Consultant Response to Drainage Comments

D1623 - FORMER CHANDLERS BMW, WATER LANE, ANGMERING

Engineers Comments Regarding Surface Water Drainage:

| Date  | February 2019 | Drawing No. | 2018-D1623-PL301 | Rev        |    |          |    |

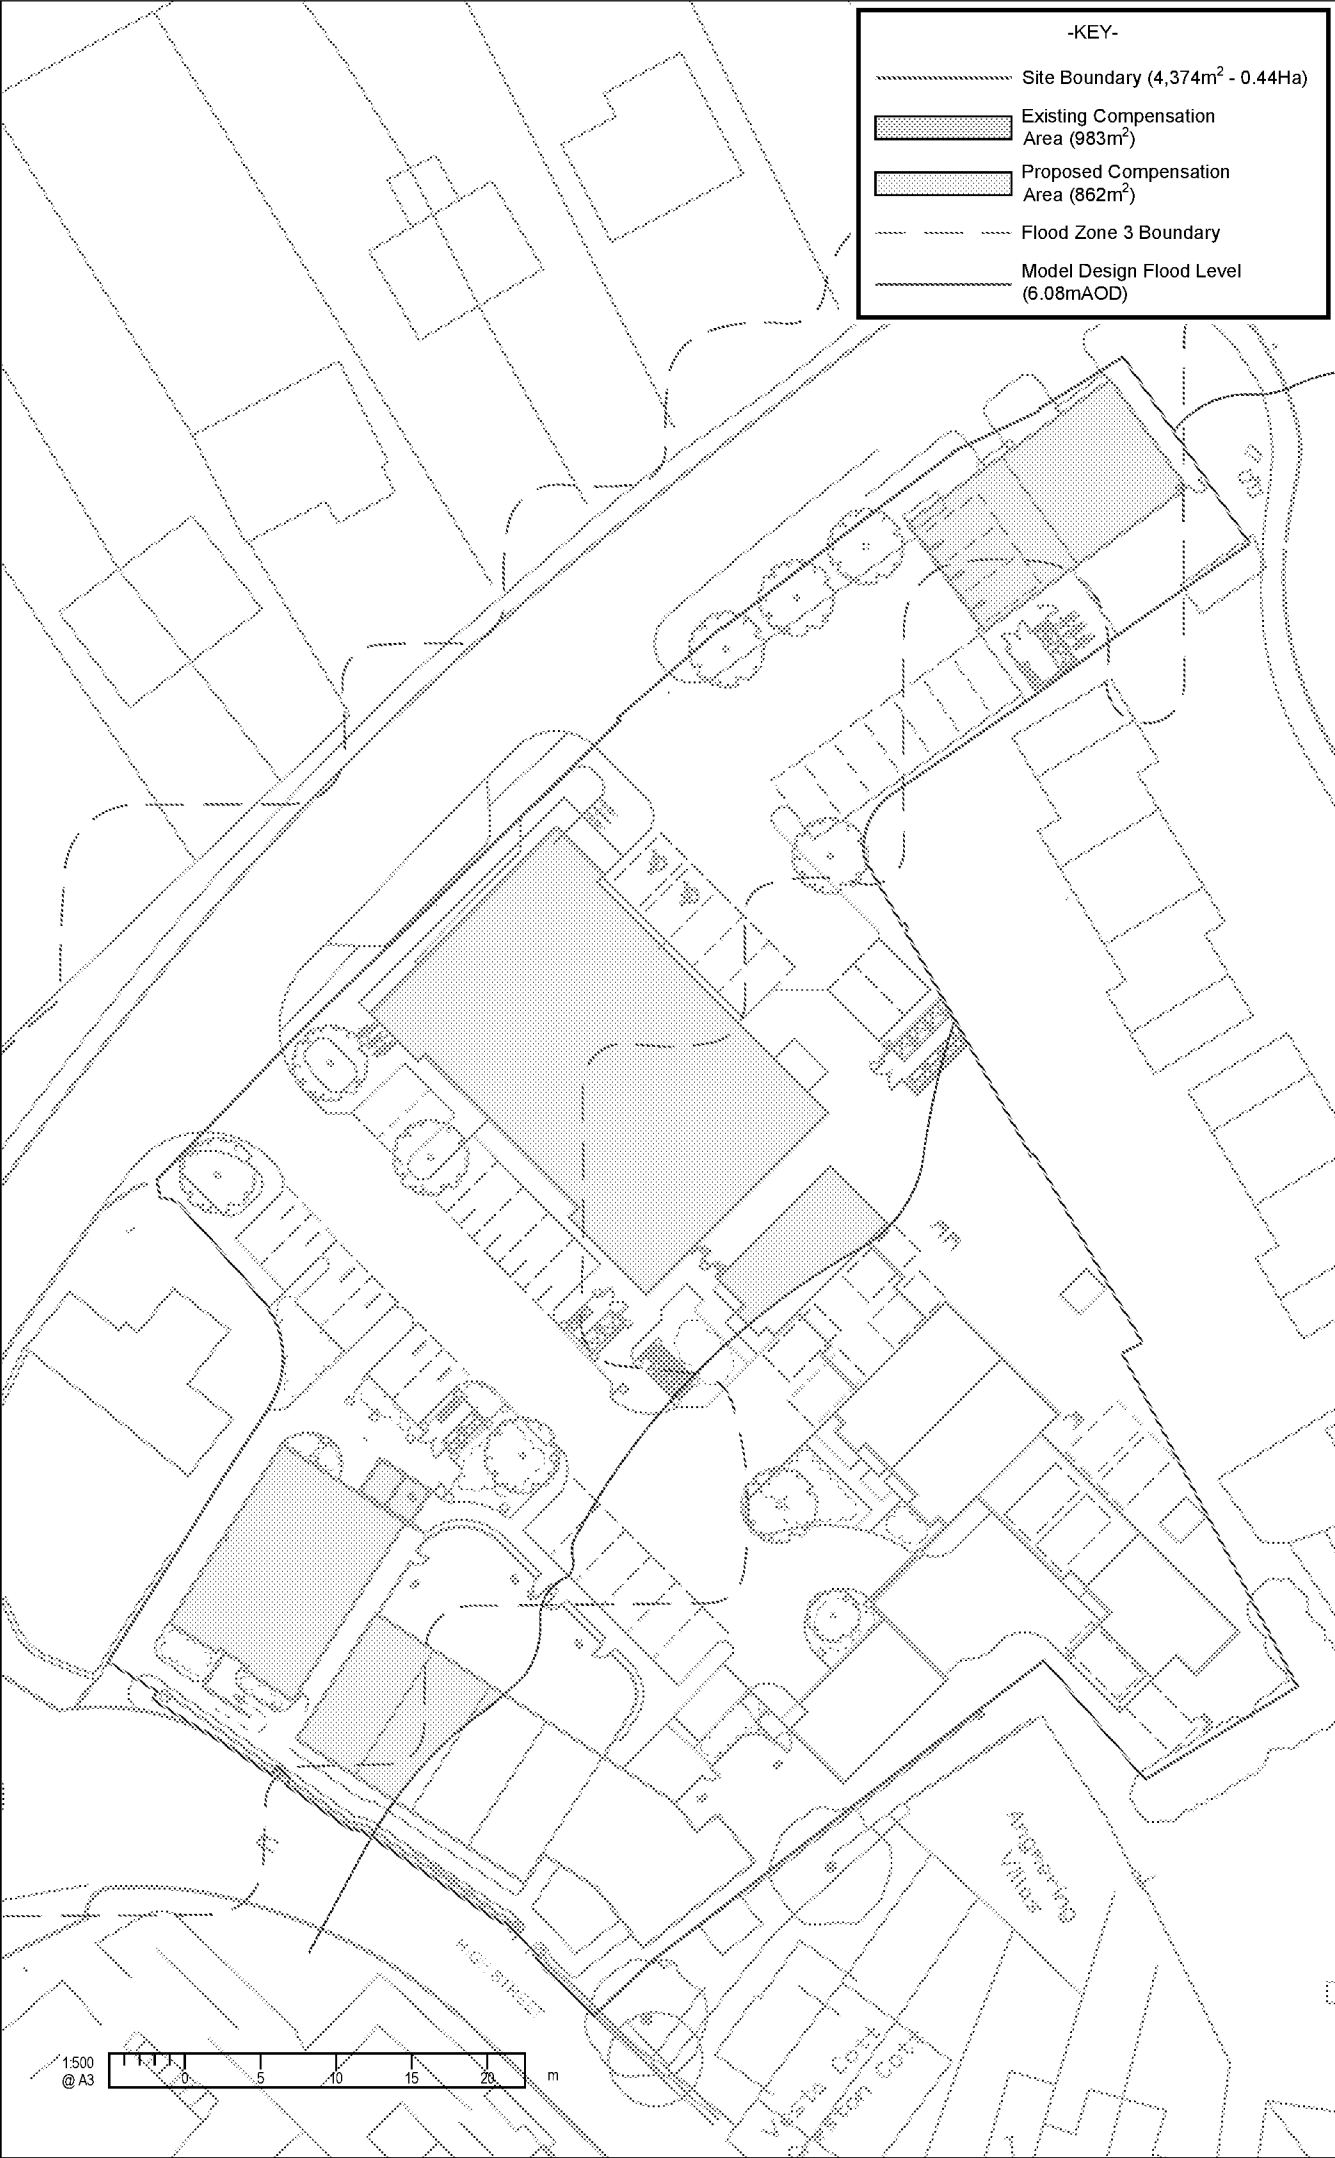
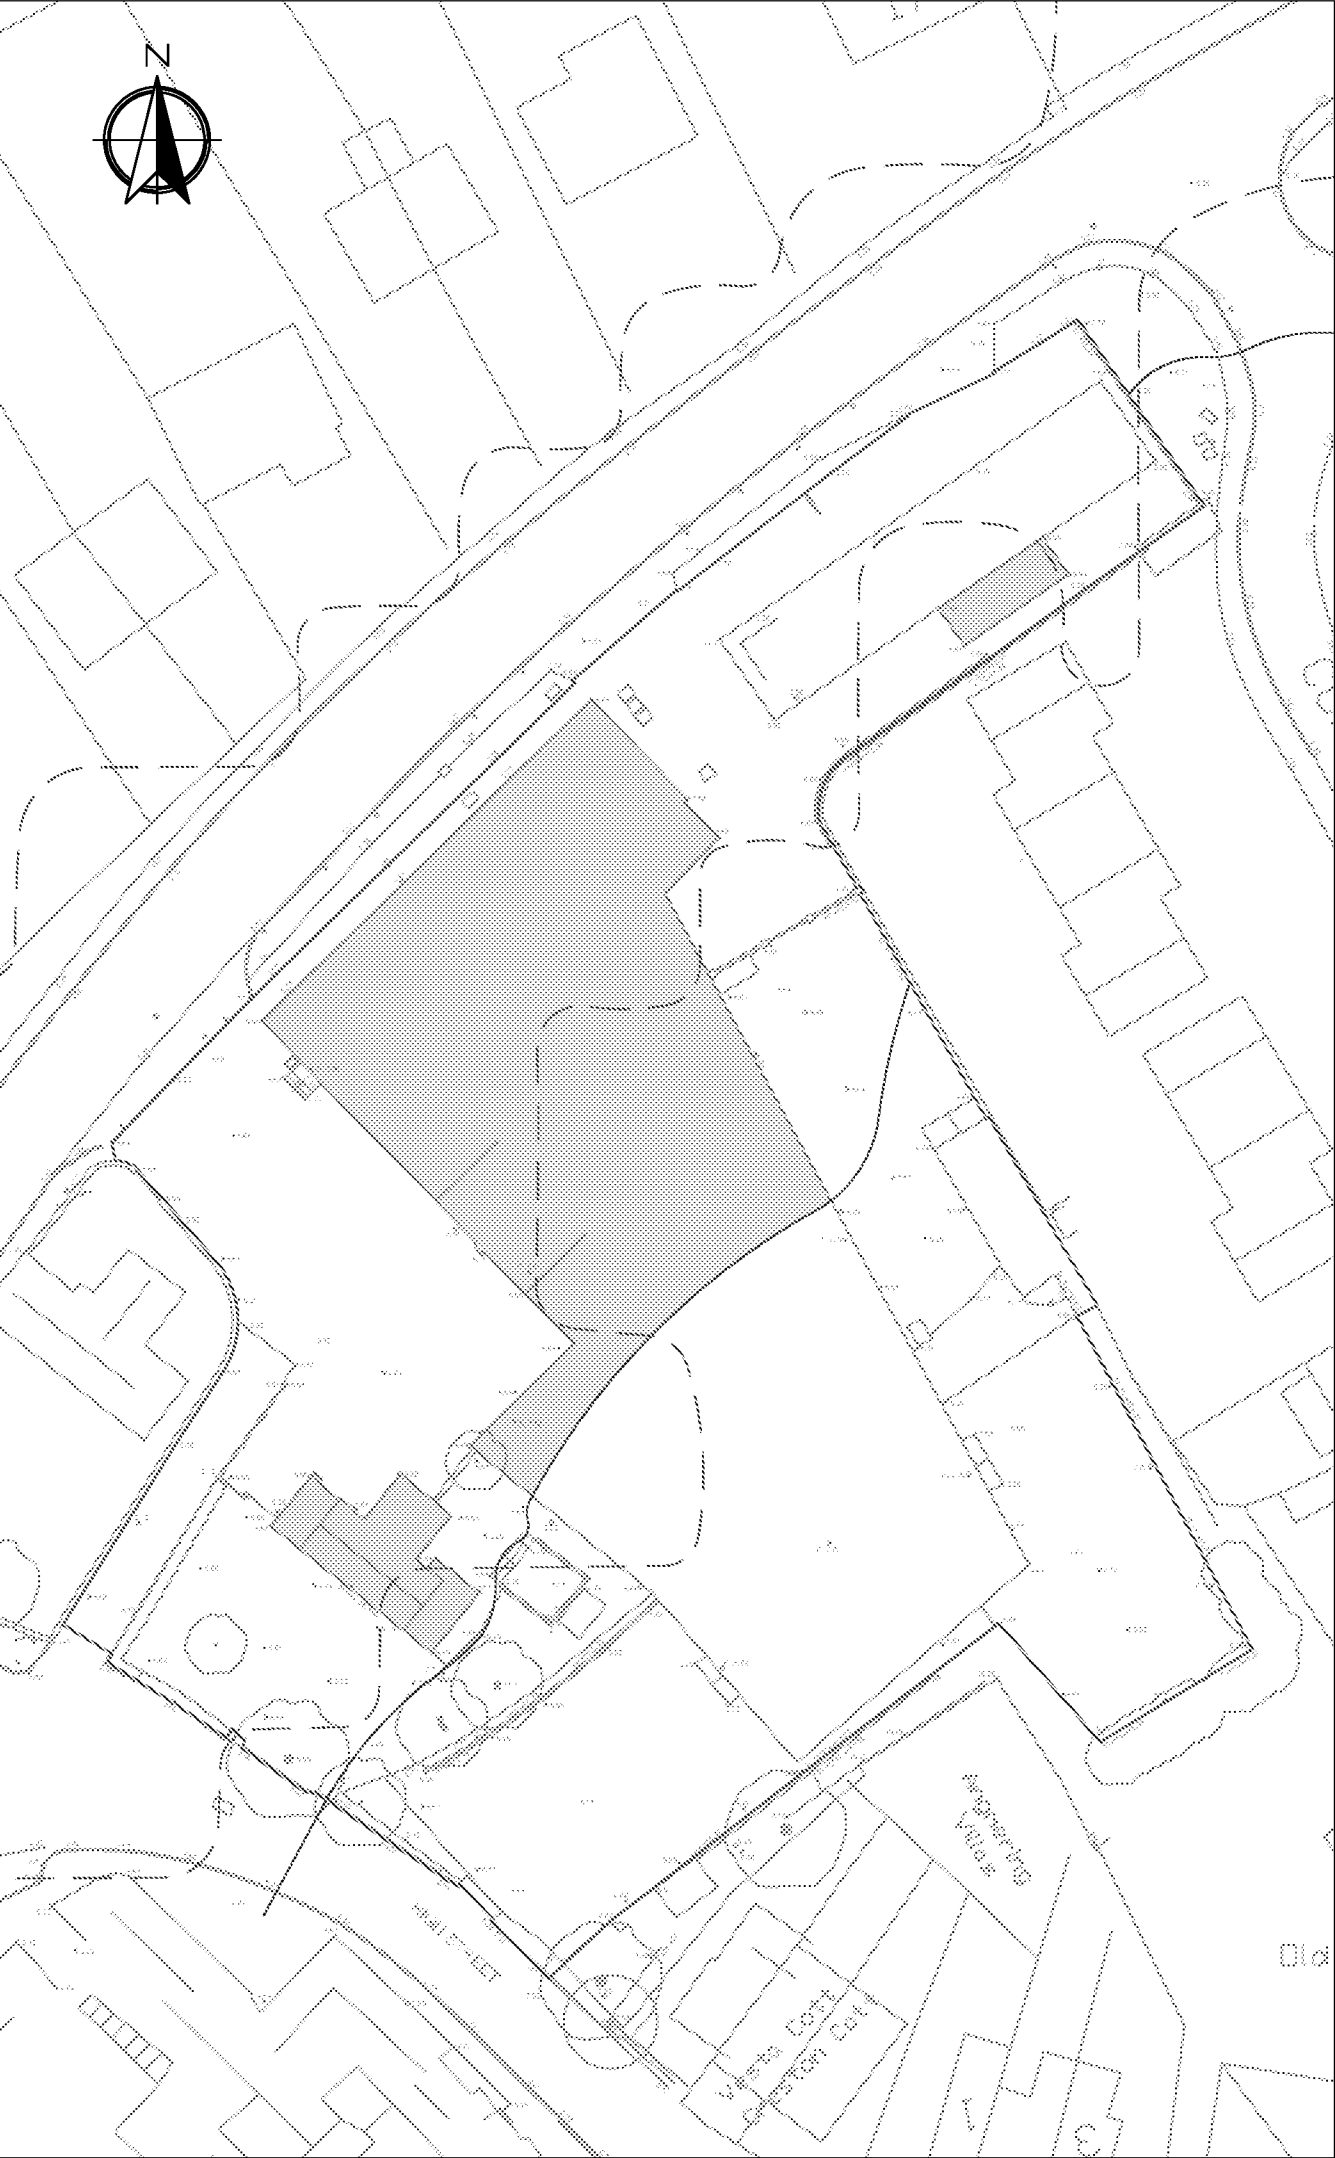
The site is also at risk of surface water flooding. Proposed attenuation or infiltrating structures must be located outside of the predicted fluvial and pluvial extents.

The proposed drainage strategy has considered modelled flood levels and the design flood level in accordance with the existing and proposed site layout and the recorded topographic levels in order to design the attenuation features outside of the flood extents, or above the design flood level via blue roofs. The proposed development would be levelled so that drainage measures were above the design flood level, as demonstrated in DWGs PL301 and PL400, to be refined at detailed design stage.
